DEVELOPMENT INTERNAL MEMORANDUM

APPLICATION FOR PLANNING PERMISSION PLANNING POLICY CONSULTATION RESPONSE

Planning Application No.	14/01932/OUT
Address / Location	Land east of A361 Bloxham Road and south of Salt Way, Banbury
Proposal	Up to 1000 dwellings together with a mixed use local centre (including A1 retail up to 1000sq m, financial services (A2), restaurants, pubs and takeaways (A3, A4, A5), community uses (D1), primary school, green infrastructure including formal (including playing fields) and informal open space, landscape and amenity space, changing and sports facilities (including D2), sustainable drainage systems, highway, cycle and pedestrian routes, car parking, infrastructure (including utilities), engineering works including ground modelling, demolition, site reclamation and removal of structures, and the formation of a new access from the A361 Bloxham Road.
Site Details	<p>The site is a greenfield site comprising agricultural land to the south of Salt Way and east of the A361 Bloxham Road, which forms the western boundary of the site. The north west portion of the site wraps around a land parcel the subject of planning permission for 145 dwellings granted on app

Figure 14 - Development Framework Plan

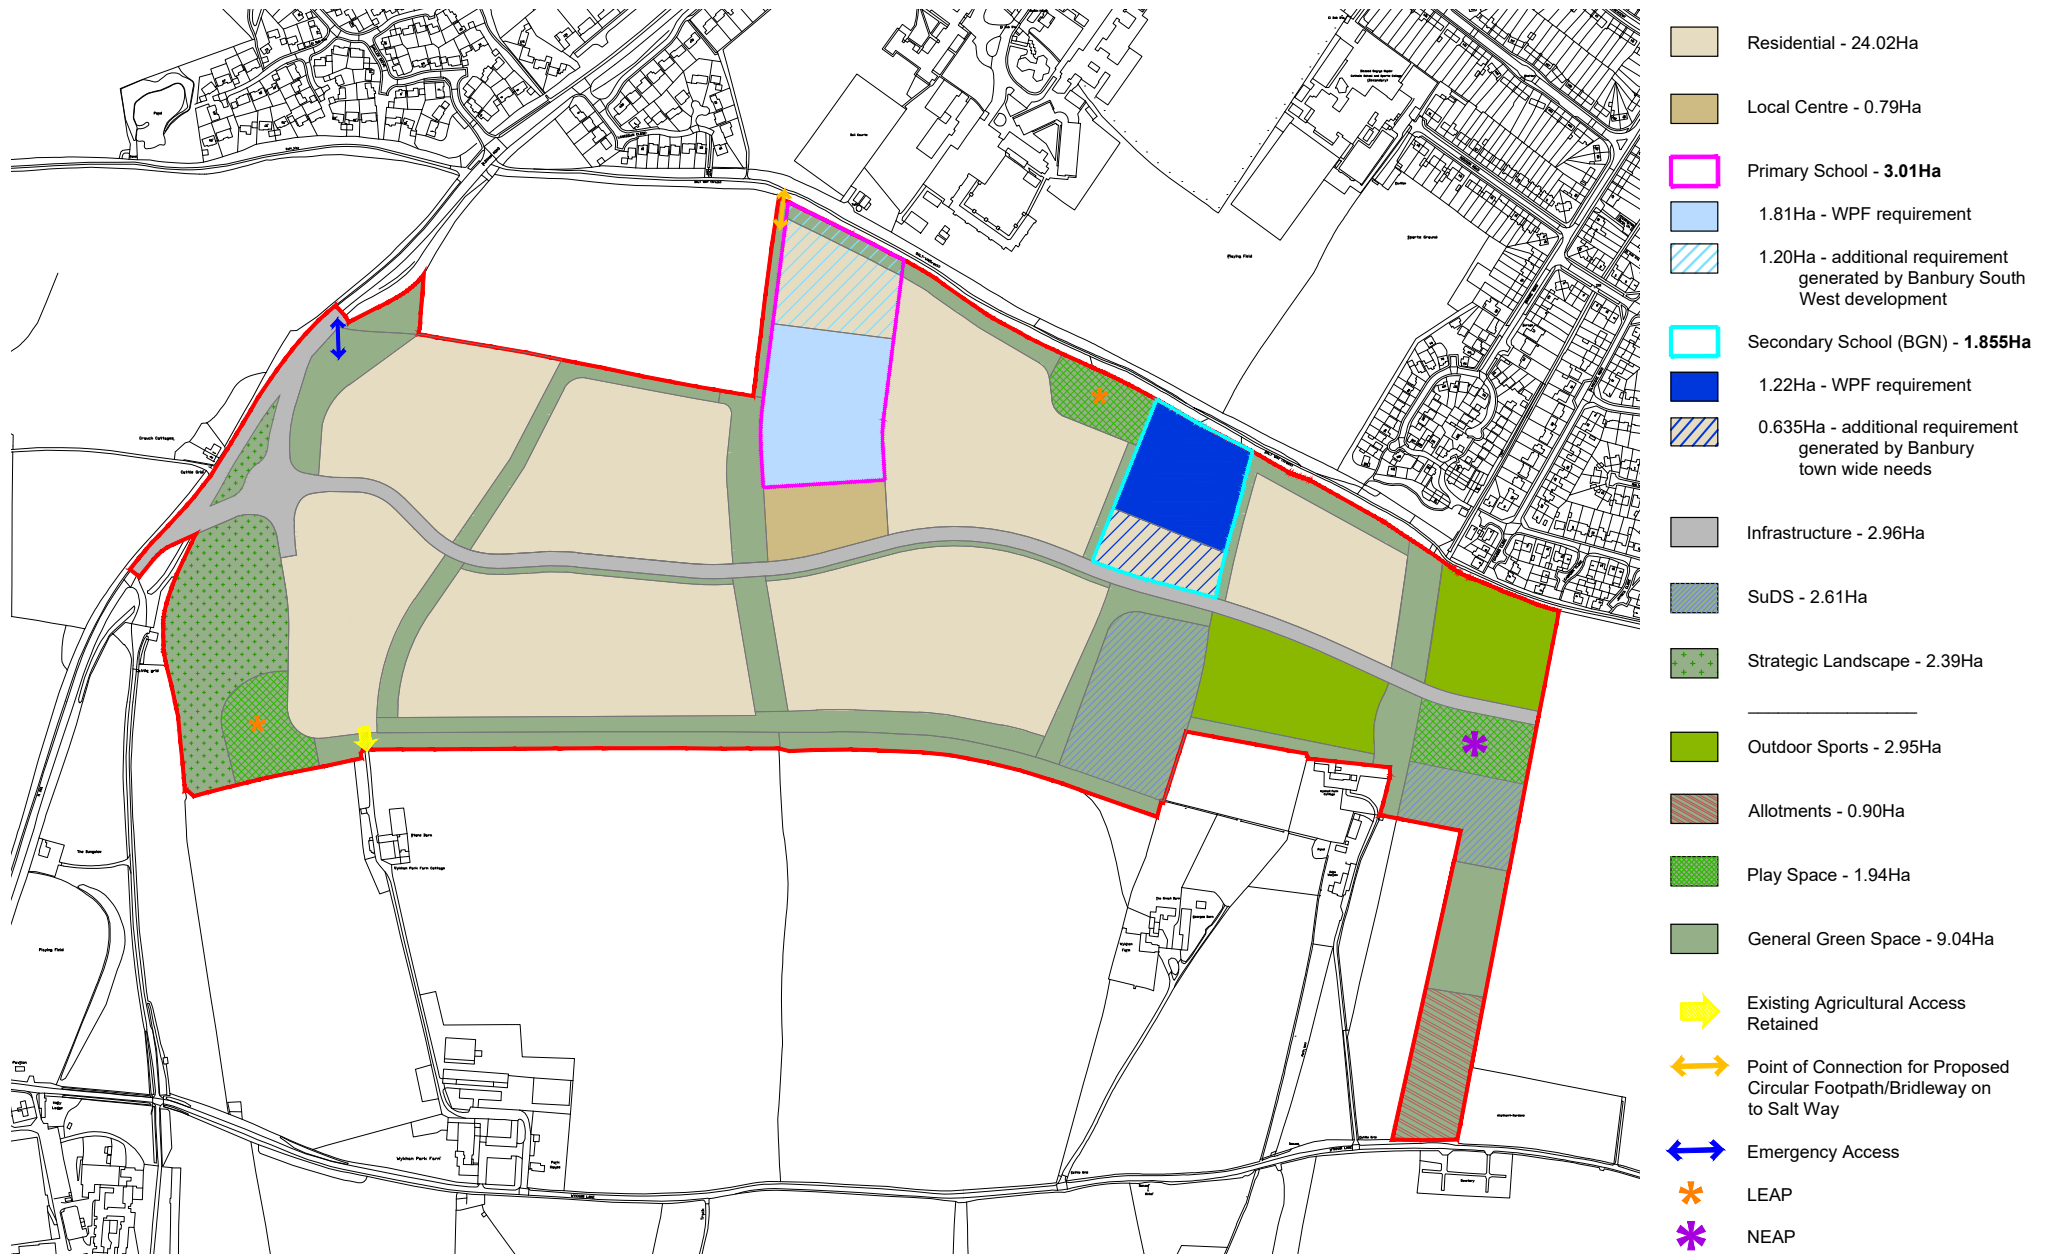
Footpath route 47 is not indicated on the Development Framework Masterplan and is partly covered by residential development. The proposed new footpath/bridleway along the southern boundary of the site required by Policy 17 is not specifically indicated on the Development Framework Plan or the illustrative masterplan for the application site. There needs to be further indication that this will be provided to ensure the requirements of the policy are met and adequate green infrastructure links are secured.

Figure 20 – Movement Network

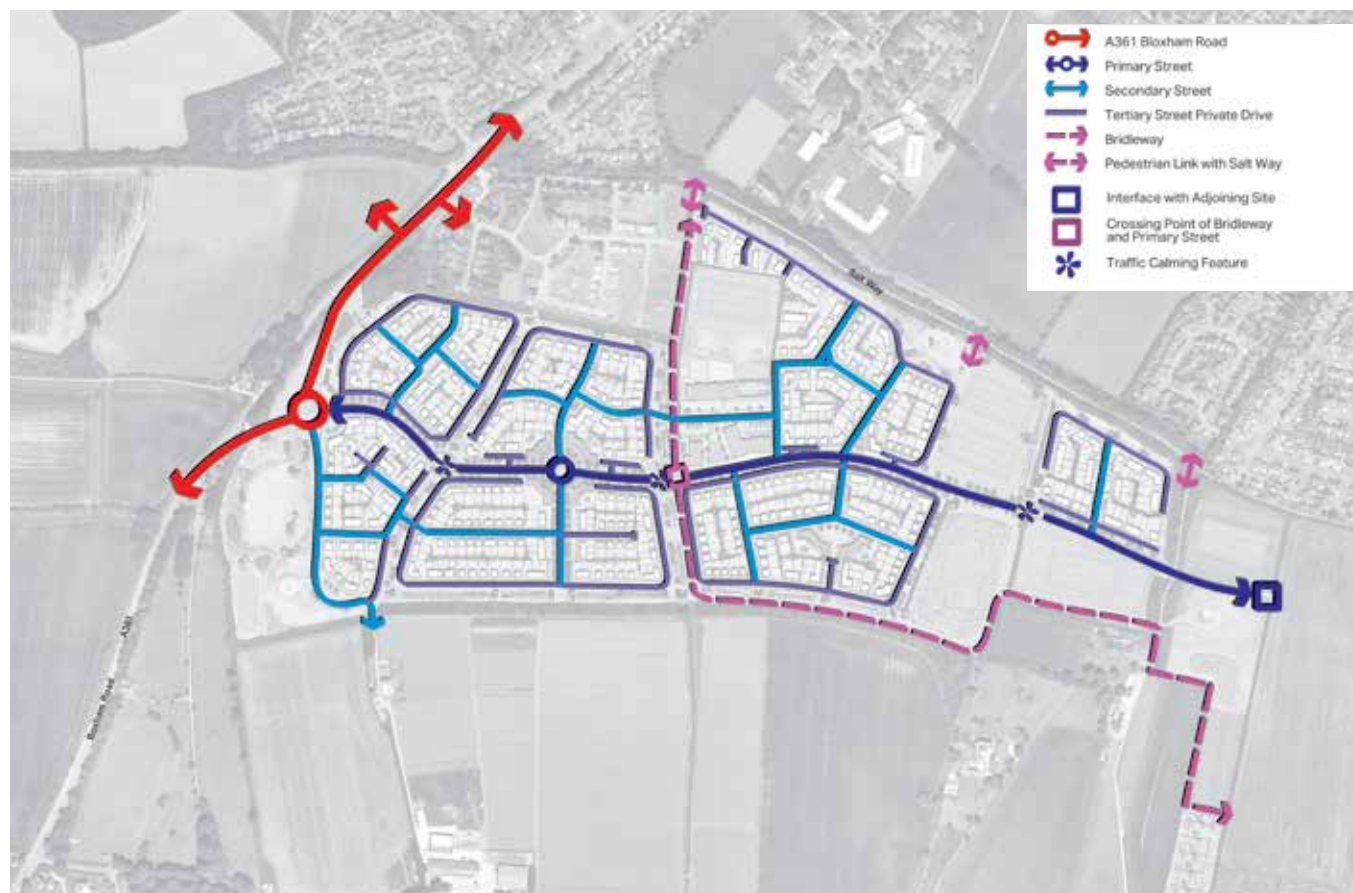
The illustrative masterplan for the application includes a “spine road” running through the site from east to west but does not fully extend to the eastern boundary of the site, with a hammer head shown at the edge of the area of outdoor sports/open space. This allows for the link road to be extended to the east in the future but the Planning Statement (paragraph 3.22) indicates completion of the link road is not necessary to make the development acceptable and does not form part of the application proposals. This does not meet the requirements of the Policy for a spine road to link from the A361 to White Post Road and without this being included and agreement reached with adjacent land owners there is no certainty that the alignment is suitable to link to the east and that this can be delivered. It could lead to 1000 dwellings being served from one access point.
